Proposed S4.55 (1A) Modification to SSD-35370706 Uniting Charlestown Development DA Mod 2

*Architectural Comparison –
Stamped Approved Plan & DA MOD 2 Plans*

DRAWING TITLE
FLOOR PLAN - LEVEL 02-03

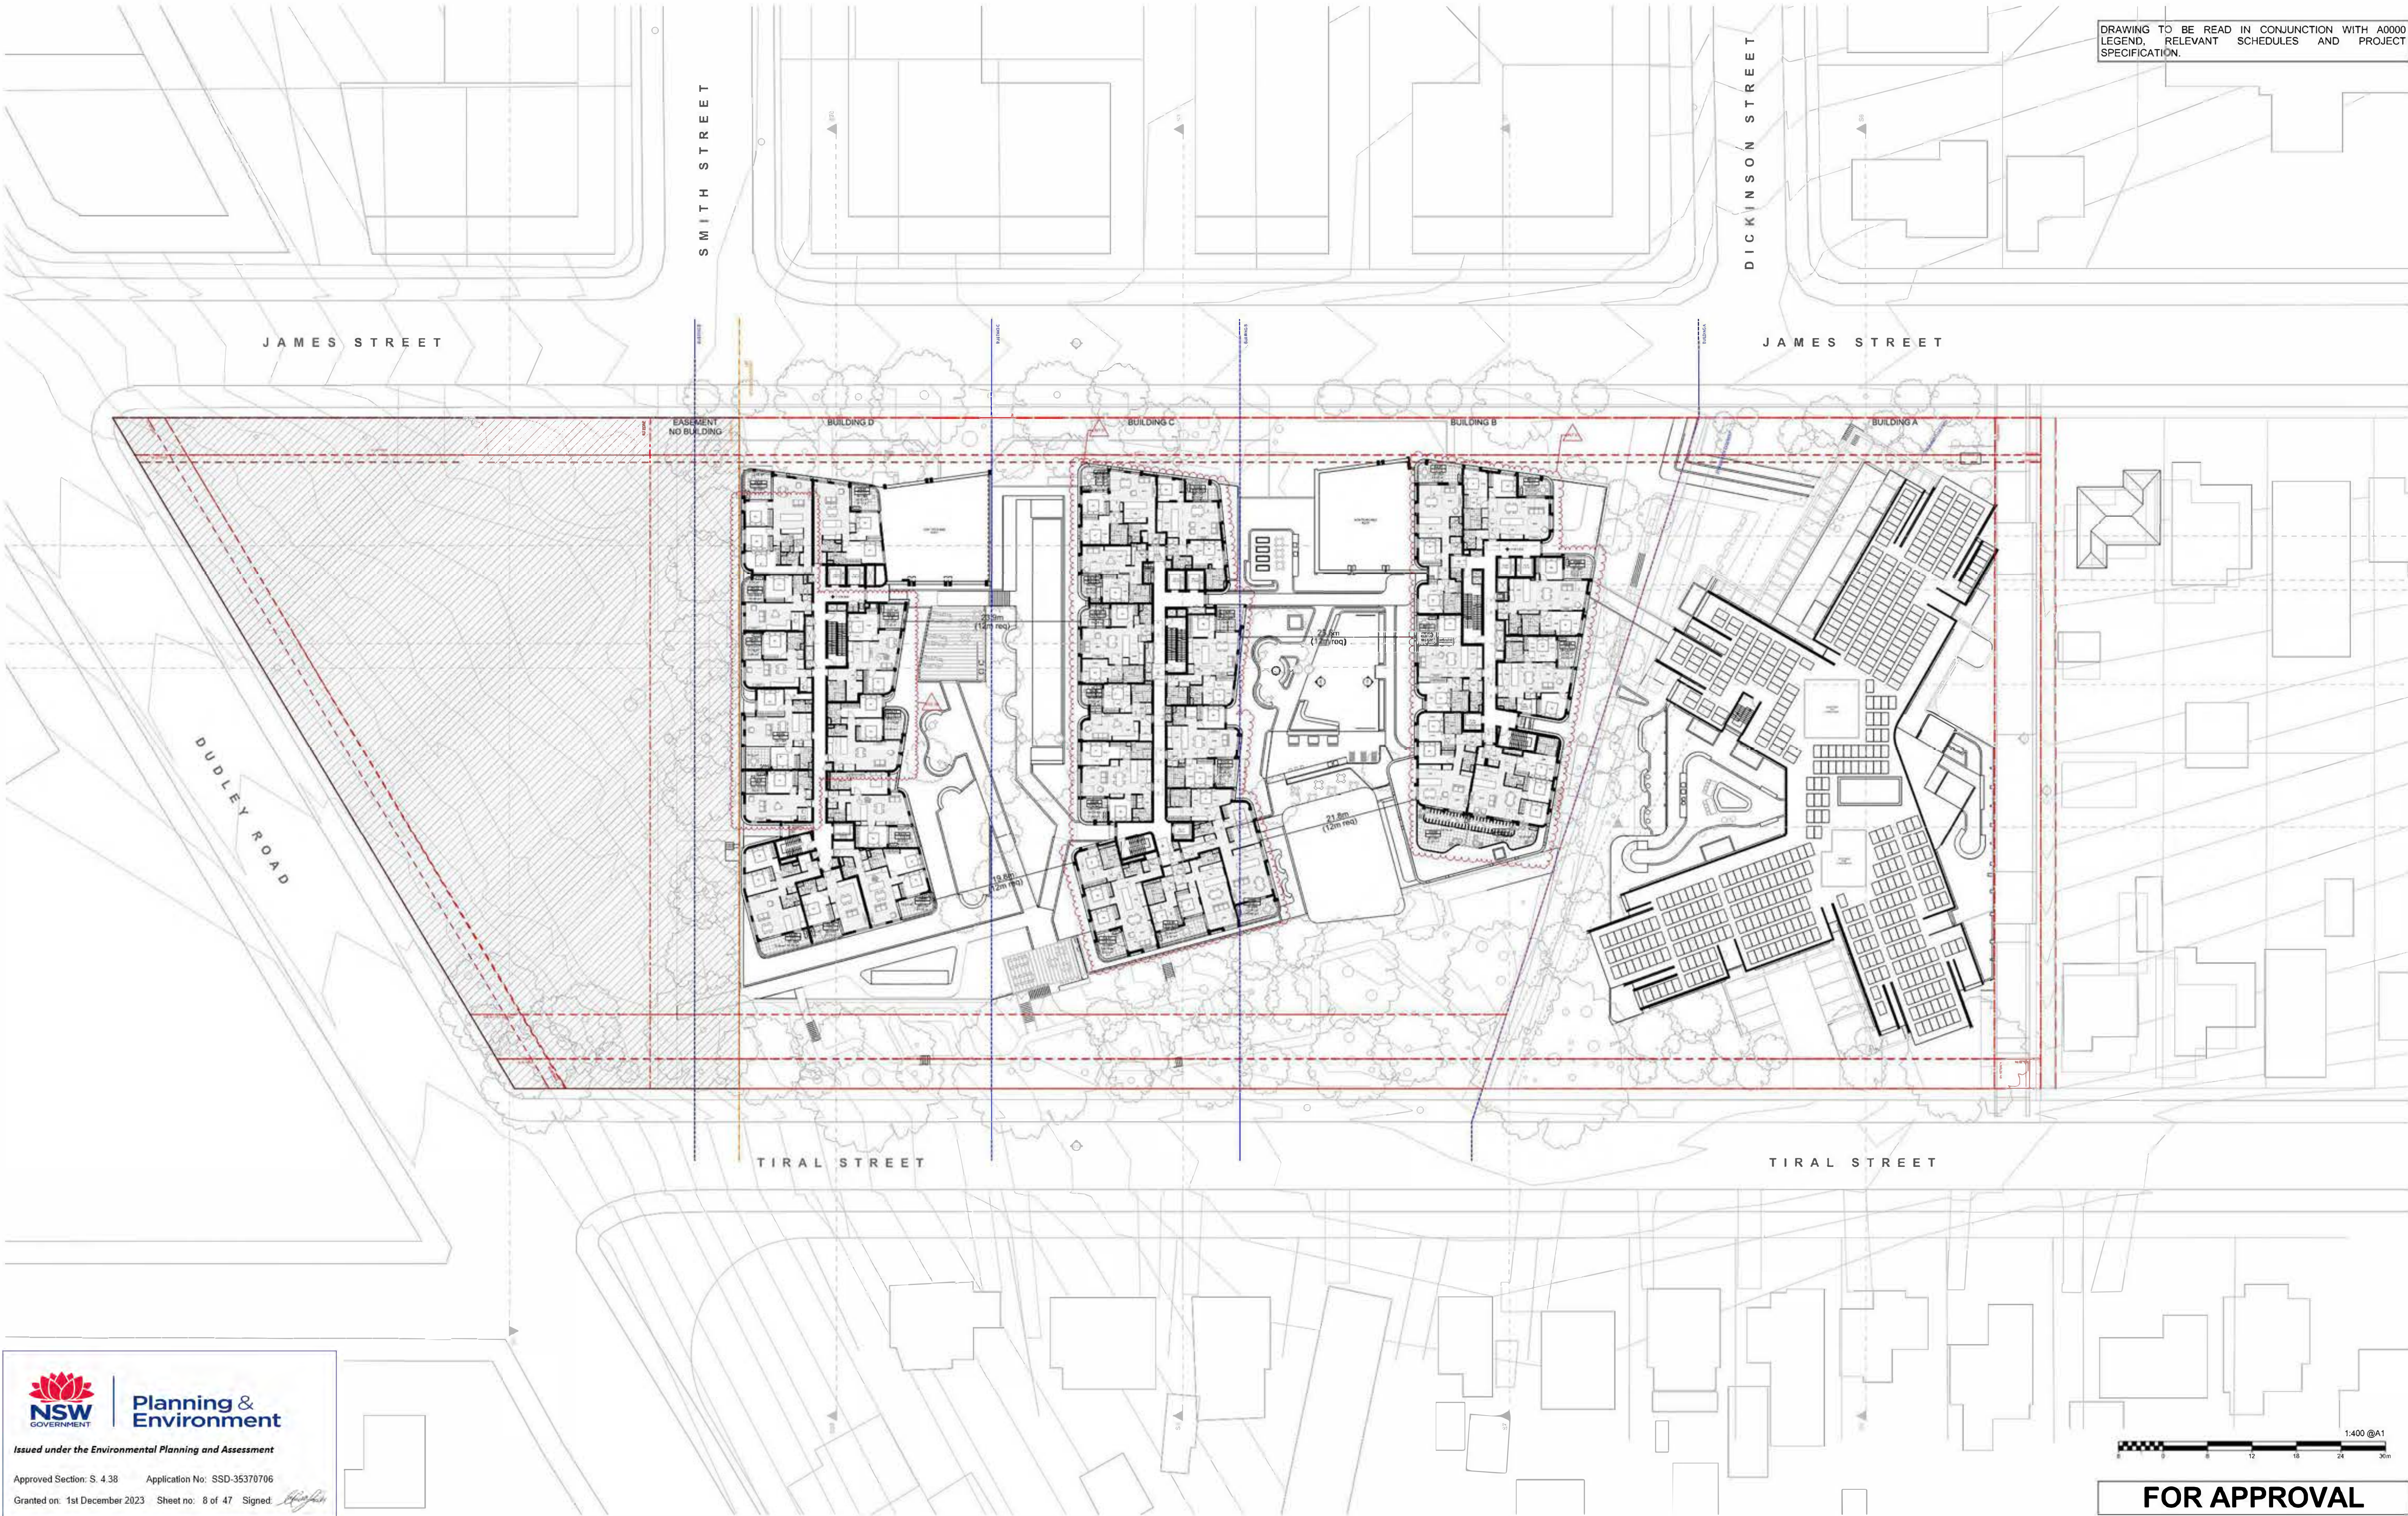
- * Internal layout adjusted to reflect ongoing stakeholder consultation and provide better amenity for occupants.
- * Change in façade layout and finishes.
- * Change in RL from RL101,000 to RL101,240
- * Straightening of 2nd lift and external wall follows - gain area 2nd Lift area has reduced

- * Internal layout adjusted to reflect ongoing stakeholder consultation and provide better amenity for occupants.
- * Change in façade layout and finishes.
- * Change in RL from RL 104,100 to RL104,440
- * Straightening of 2nd lift and external wall follows - gain area 2nd Lift area has reduced

DRAWING TITLE
FLOOR PLAN - LEVEL 05-06

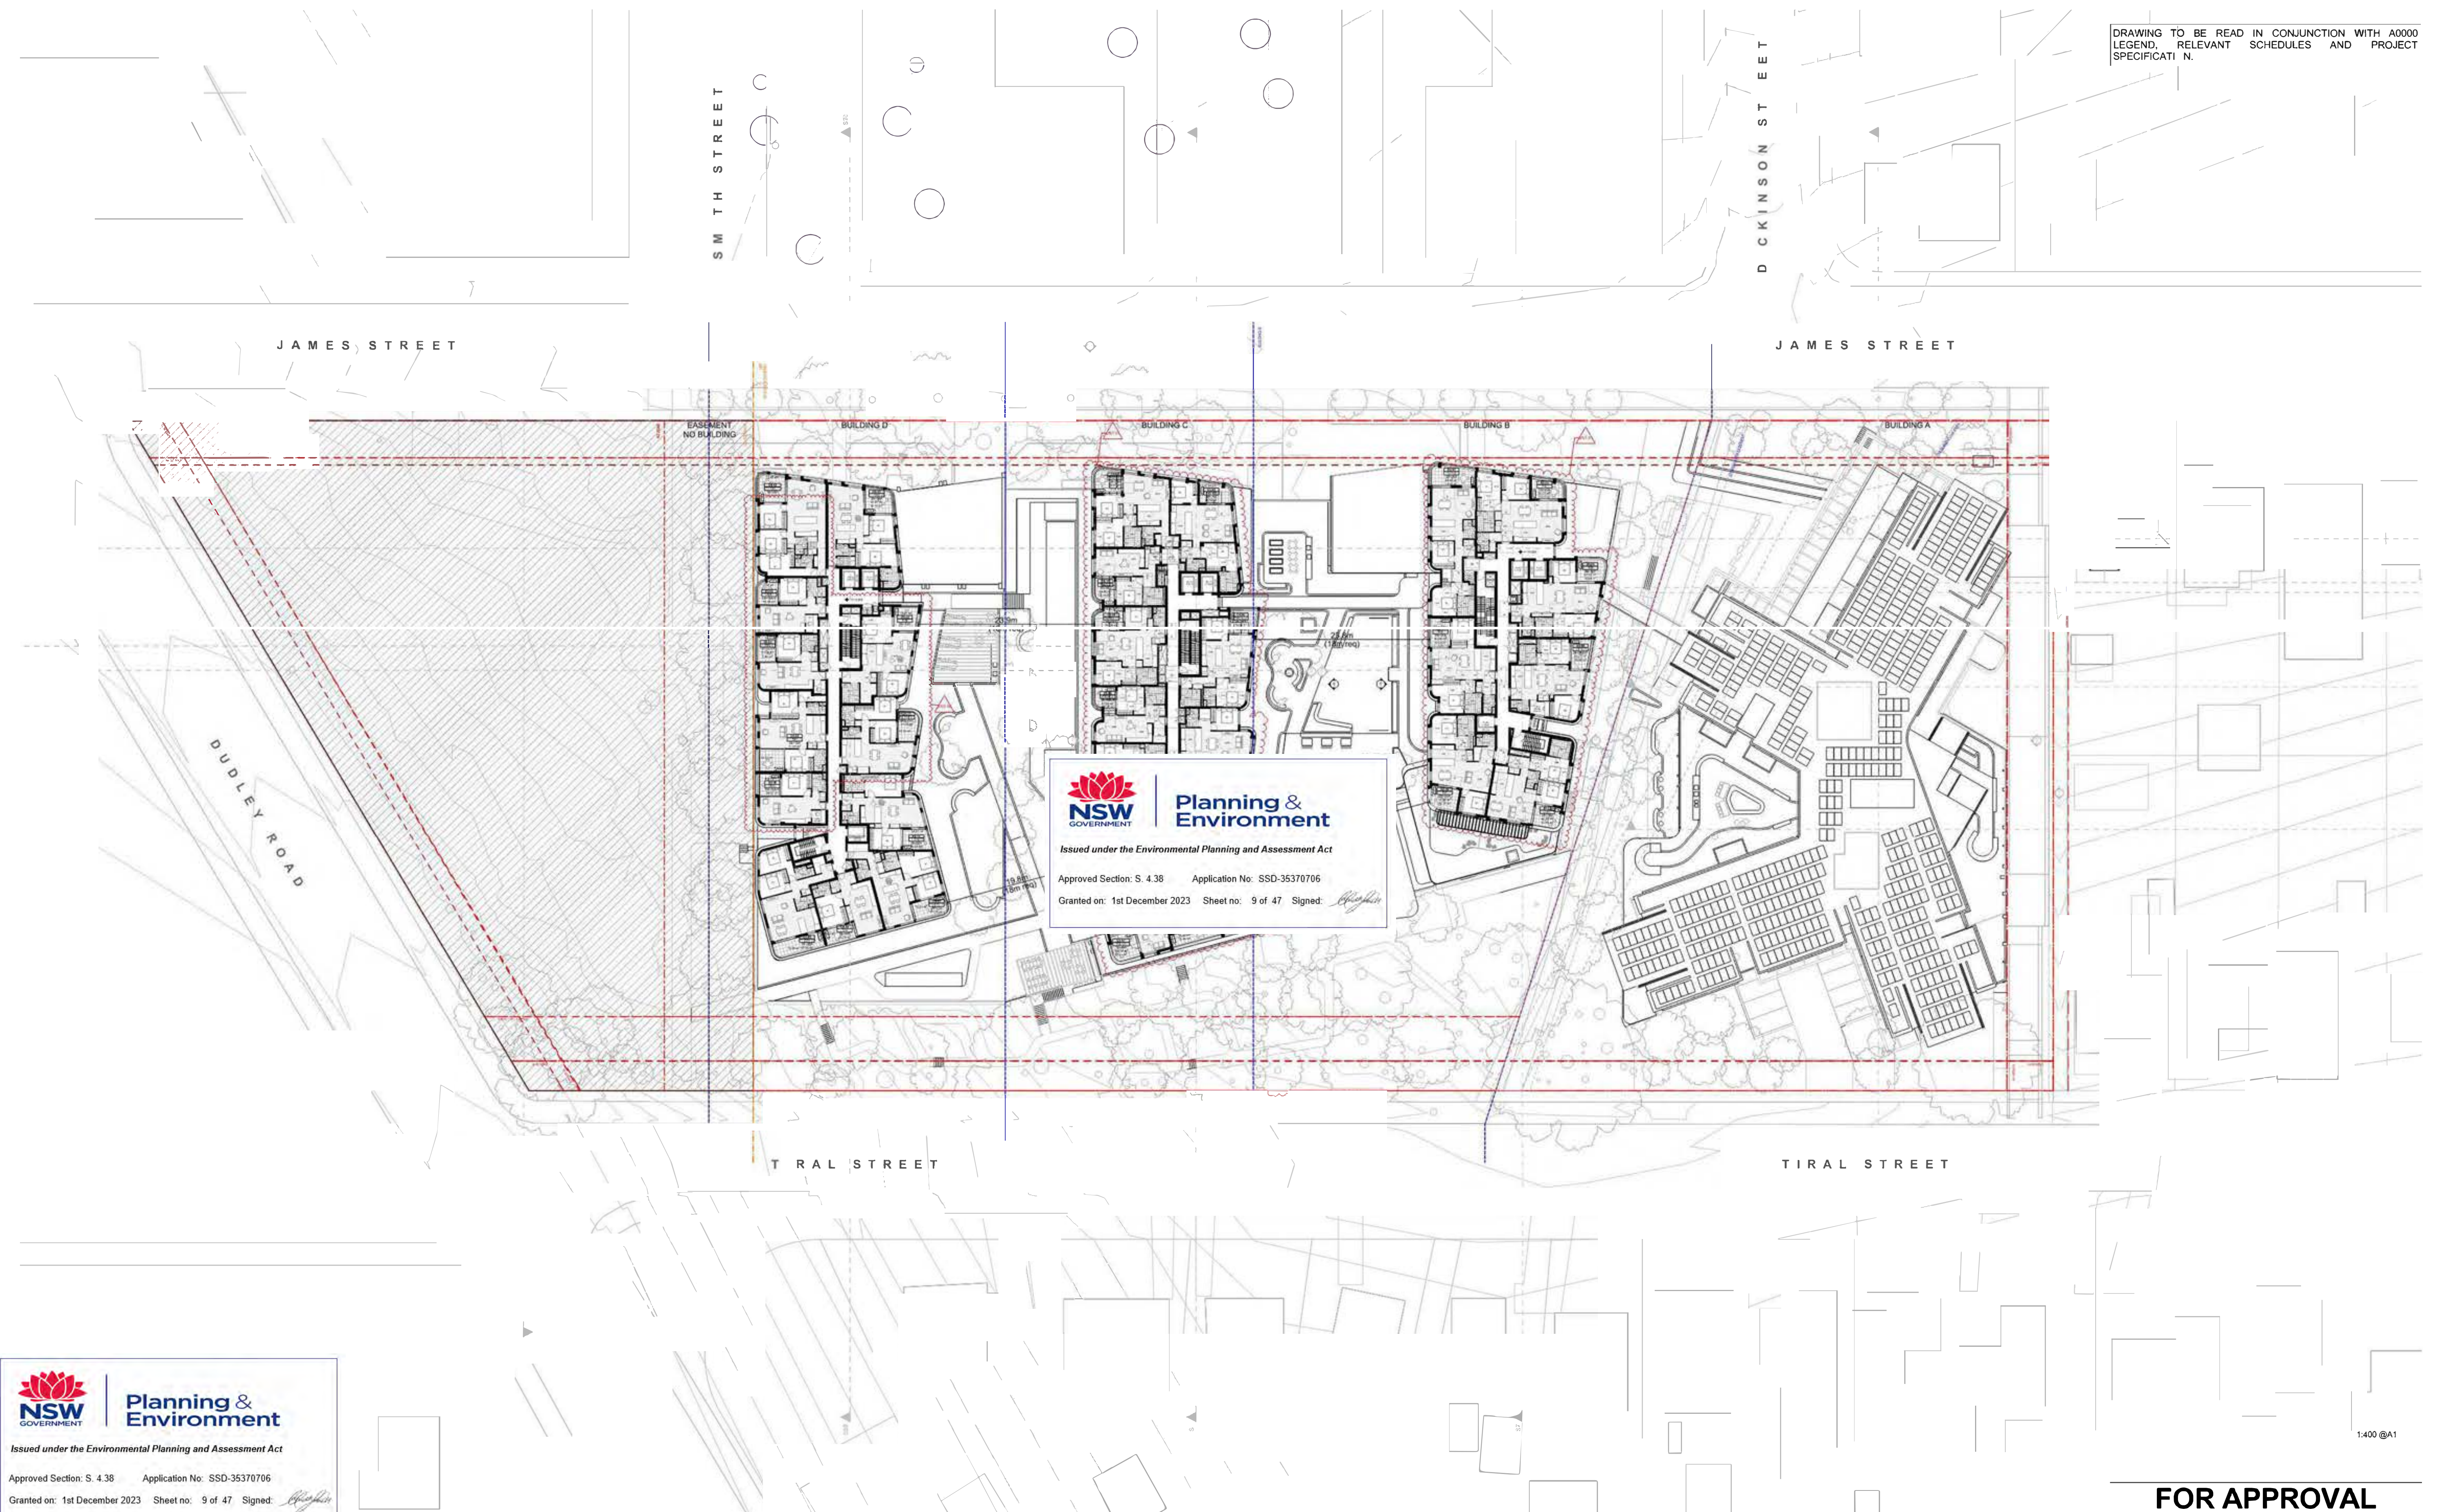
- * 2 Northern units gain area. 2Bed connects behind the Fire egress - gain area
- * Western 2 units combine - gained balcony area
- * Straightening of 2nd lift and external wall follows - gain area
- * 2nd Lift area has reduced
- * Unit 5.06 balcony ex.wall run parallel to reduce GFA
- * Change in internal layout.
- * Change in façade layout and finishes.
- * Change in RL from RL 110,800 to RL110,990

- * Internal layout adjusted to reflect ongoing stakeholder consultation and provide better amenity for occupants.
- * Change in façade layout and finishes.
- * Change in RL from RL113,900 to RL114,190
- * Straightening of 2nd lift and external wall follows - gain area 2nd Lift area has reduced
